REQUEST

Current Zoning: R-17MF (multi-family residential)
Proposed Zoning: UR-2(CD) (urban residential, conditional)

Approximately 1.53 acres located on the south side of Lynnwood Drive, west of Sterling Road, and north of Ridgewood Avenue.

The petition proposes to redevelop a site with 18 existing multi-family units to allow for the development of 21 new townhomes.

RZ-1.0

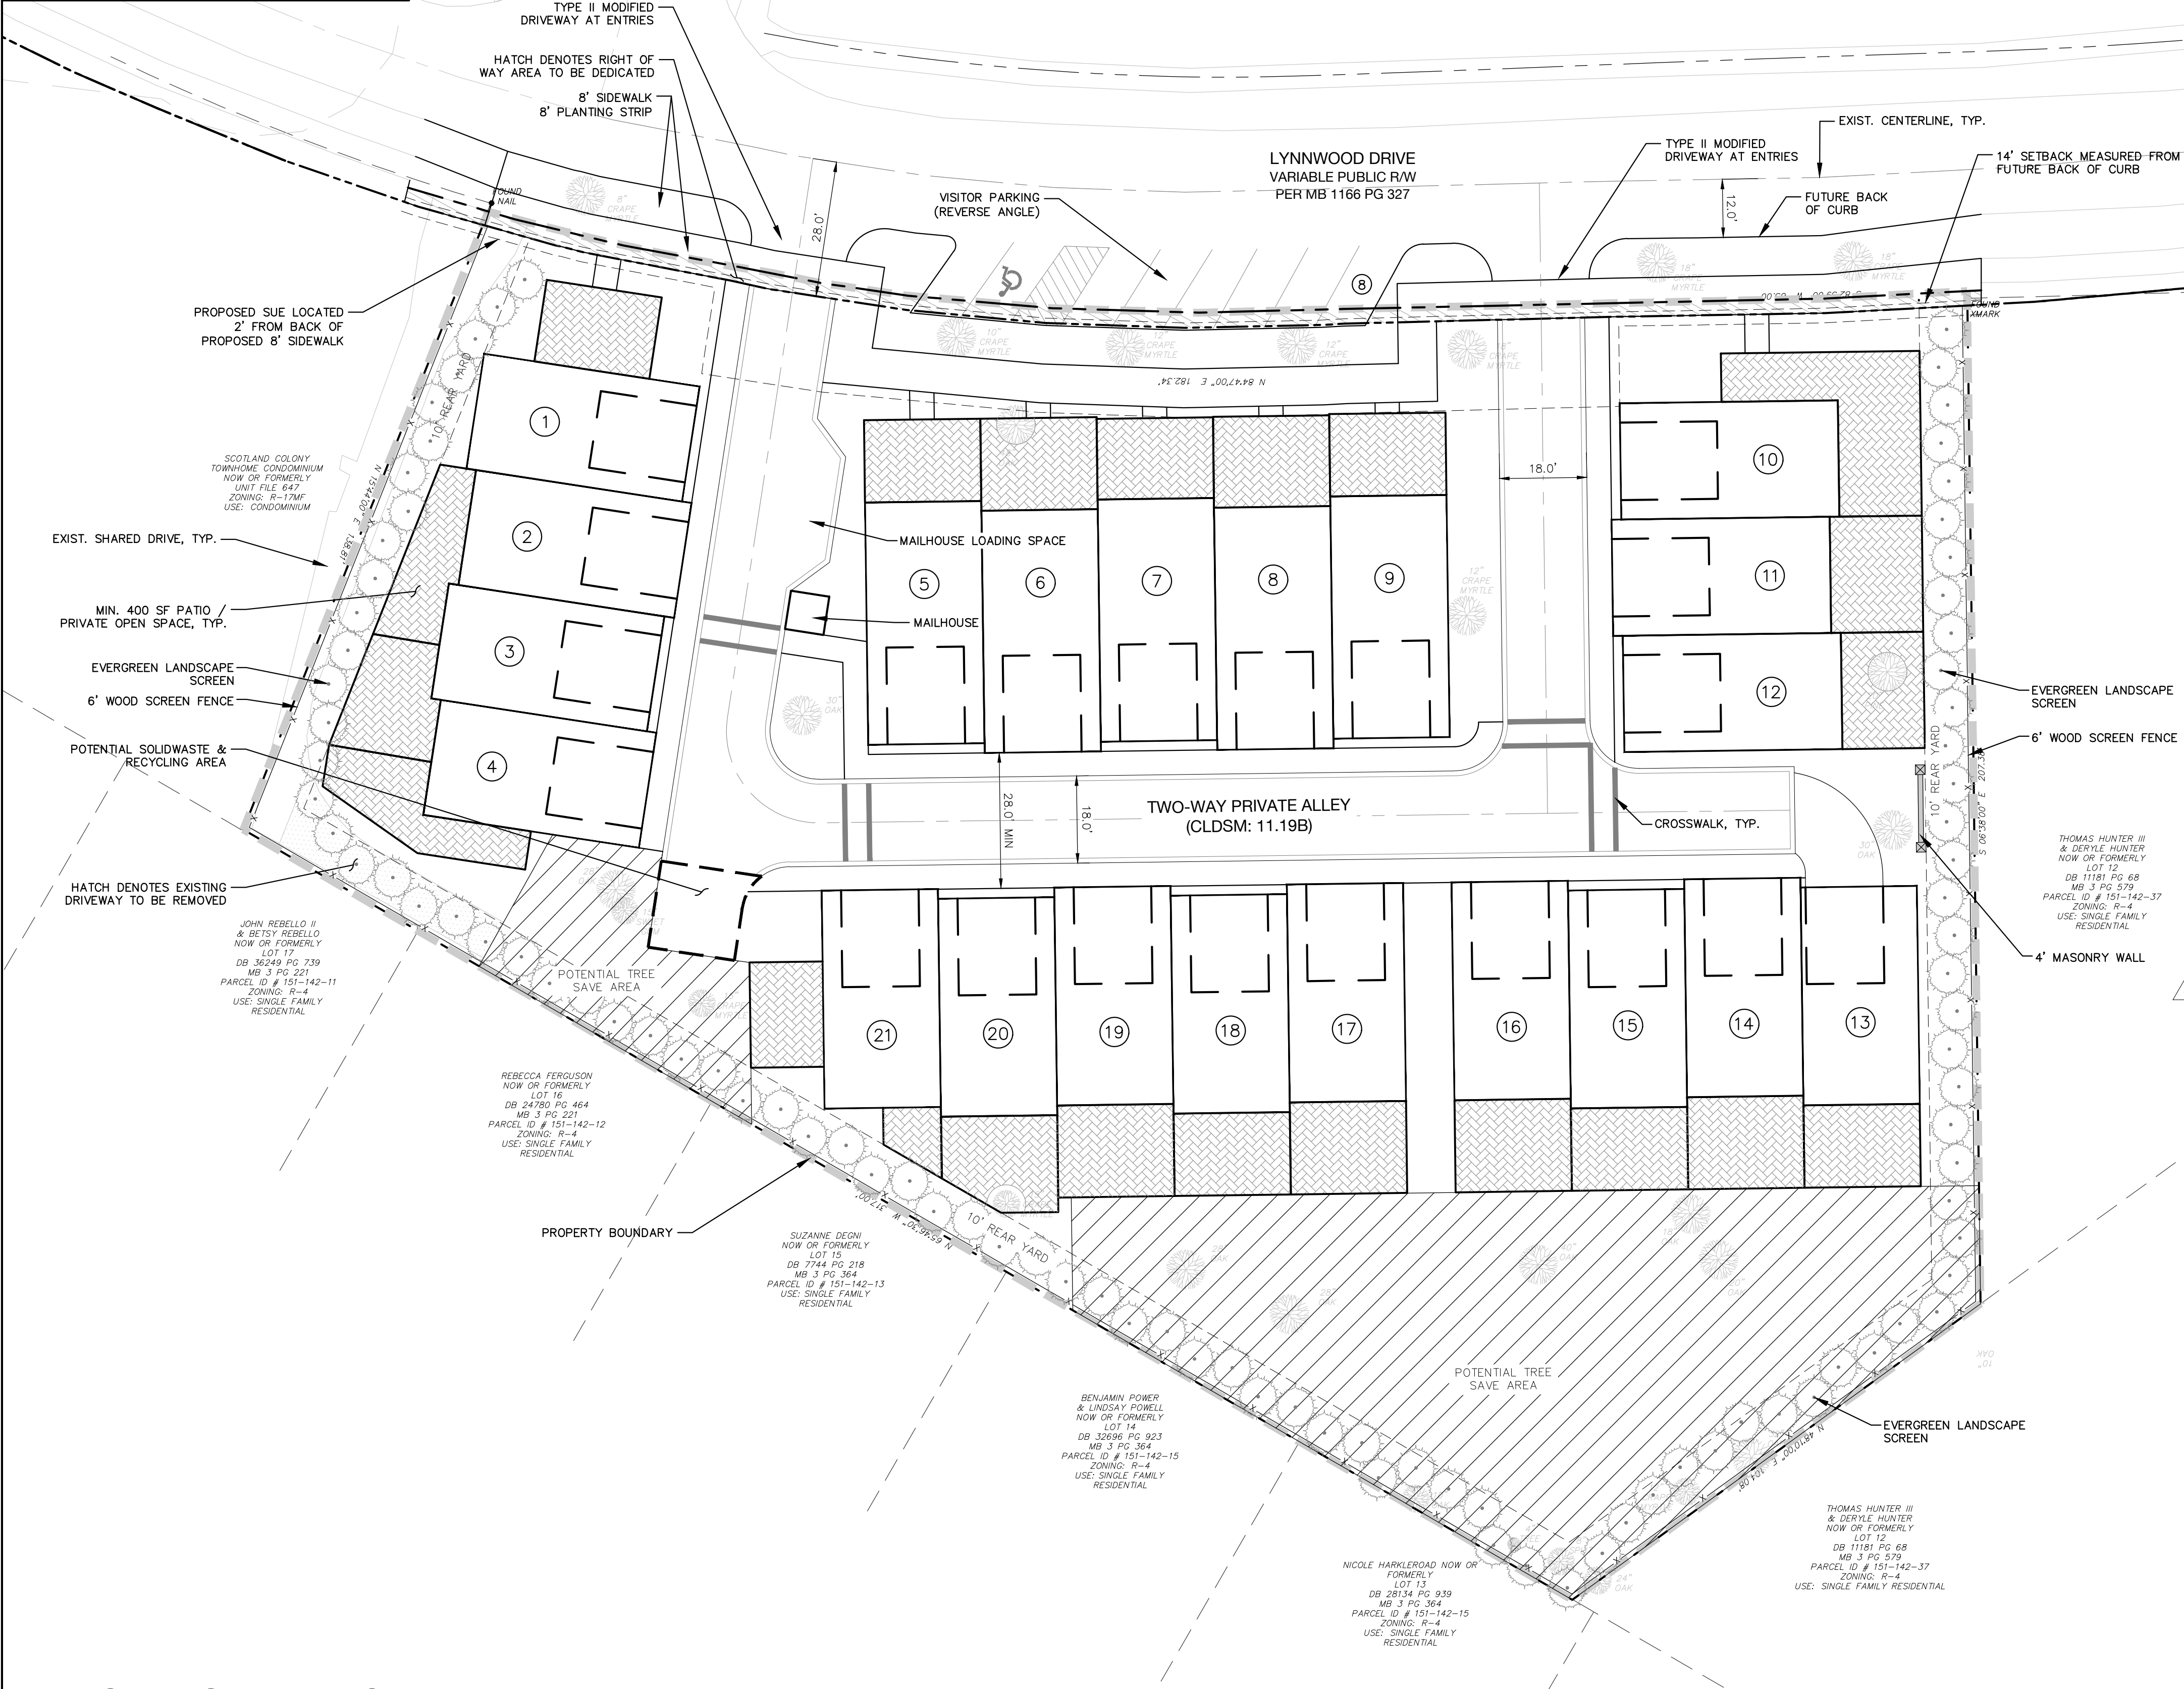
1. Label and dimension the curb and gutter from the centerline for each road on the site plan. The site plan should show dimensions as measured from the centerline to the back of curb.

2. Remove language allowing additional height beyond 40' in note g. under Architecture and Design Standards.

3. Clarify in the conditional notes that the arborist plan will be done prior to development plan submittal and clearly identify which trees outside of the tree save area are to remain.

4. Add note that patios shall be at-grade and covered.
5. Add language in the conditional notes specifying that the open space requirement is being met with private open space, as shown on the site plan.

6. Revise the language in note 6 of Environmental Features to clarify the rate of new plantings to existing trees.
